KITTITAS COUNTY COMMUNITY DEVELOPMENT SERVICES

RE: Transmittal of Comments – Rocky Coulee Tent Camping Conditional Use Permit and Shoreline Substantial Development Permit (CU-13-00004 & SD-13-00001)

STATE OF WASHINGTON
DEPARTMENT OF ECOLOGY

Re: CU-13-00004/SSDP-13-00001

Aquatic Critical Areas and Buffers

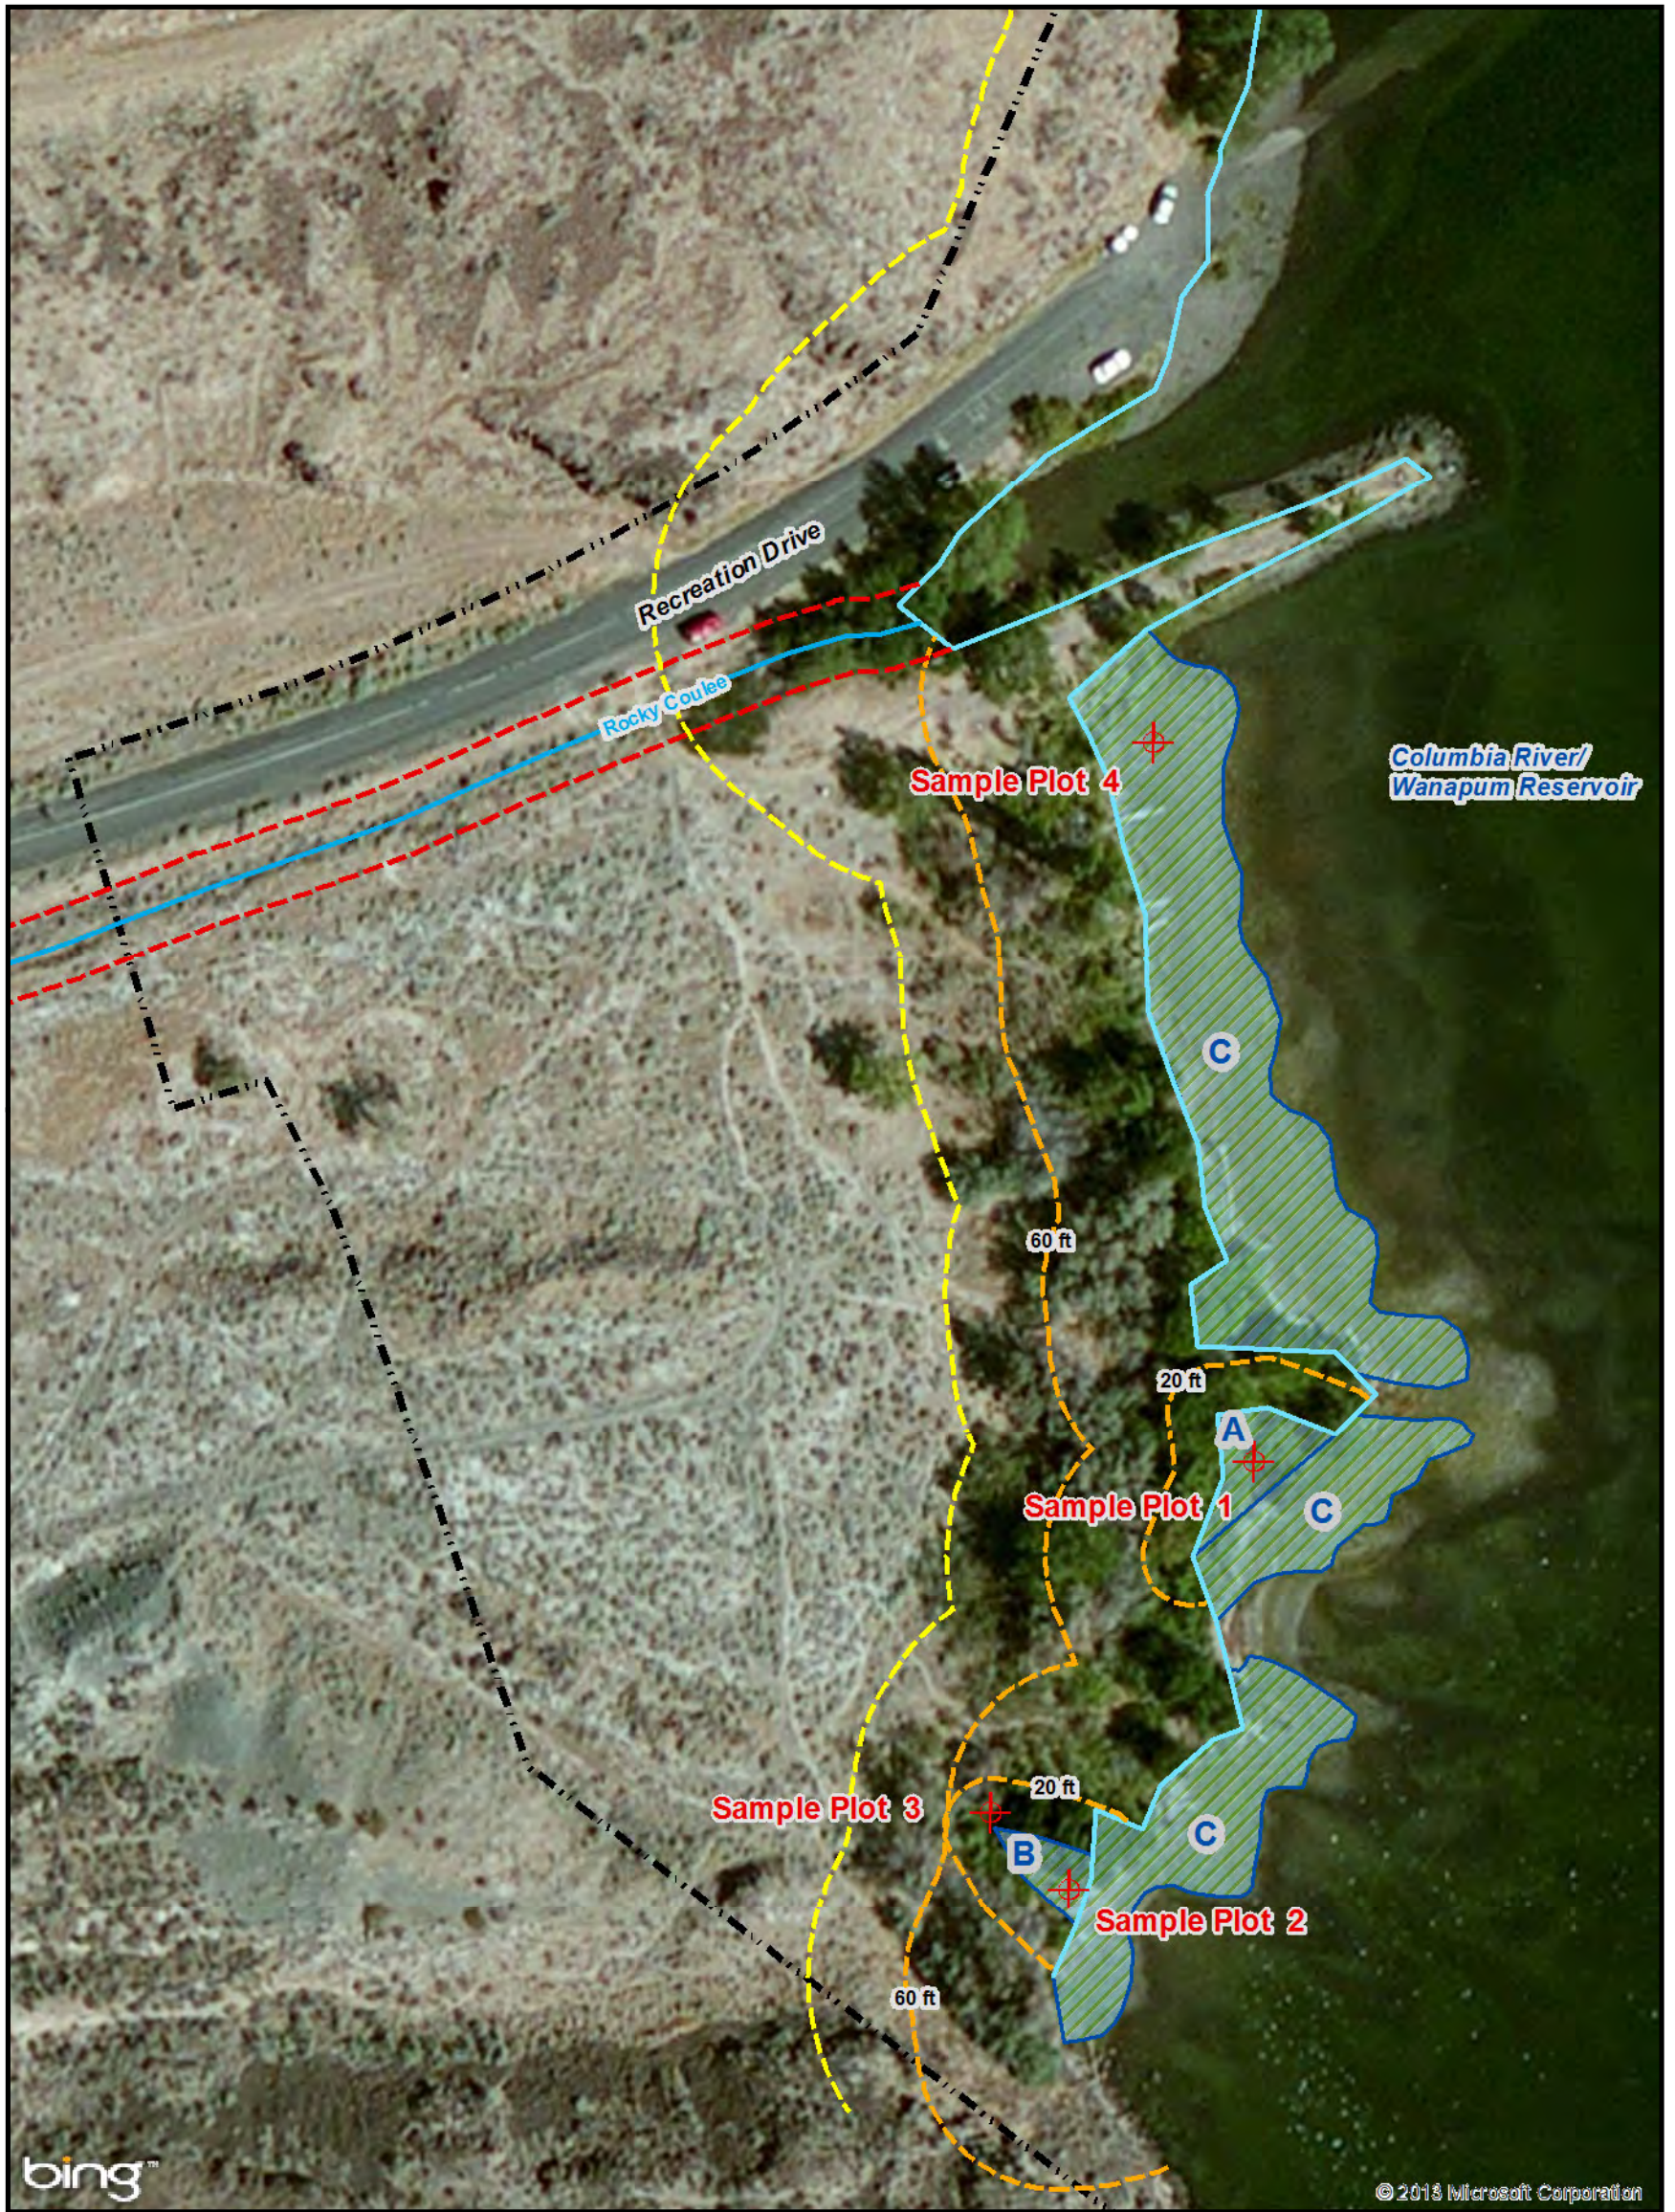
The delineation report states that the western edge of wetland C corresponds with the Ordinary High Water Mark area of the Columbia River. More explanation about this abrupt edge should be put in the wetland document because the pictures provided (and my memory from the site visit) indicate that this is a very shallow shoreline except in the location of the jetty. If the shoreline is shallow, water would wick-up at least 6 inches through even sandy soils so that the wetland edge would normally be higher than the Ordinary High Water Mark. This may move the wetland delineation line to the west depending on the shoreline elevation across the floodplain

The report needs to explain why the wetlands were split up into 3 separate areas for the purpose of rating when it appears that they are contiguous and have identical hydrologic inputs and an identical HGM class. Contiguous wetland areas should be rated as one wetland area unless there is a clear hydrologic distinction or physical barriers between areas. This distinction is important as the rating of the contiguous wetland could translate into requirements for buffers and mitigation of impacts.

Information on why the lowest buffers (of 20 feet) was listed in the wetlands table for wetlands A and B, compared to wetland C when buffers for category III wetlands in Kittitas County include a range of between 80 to 20 feet. The current report lists all the

wetlands as being category III wetlands. It is noted in the table that Ecology generally recommends buffers of 60 feet for category III wetlands from medium type impacts.
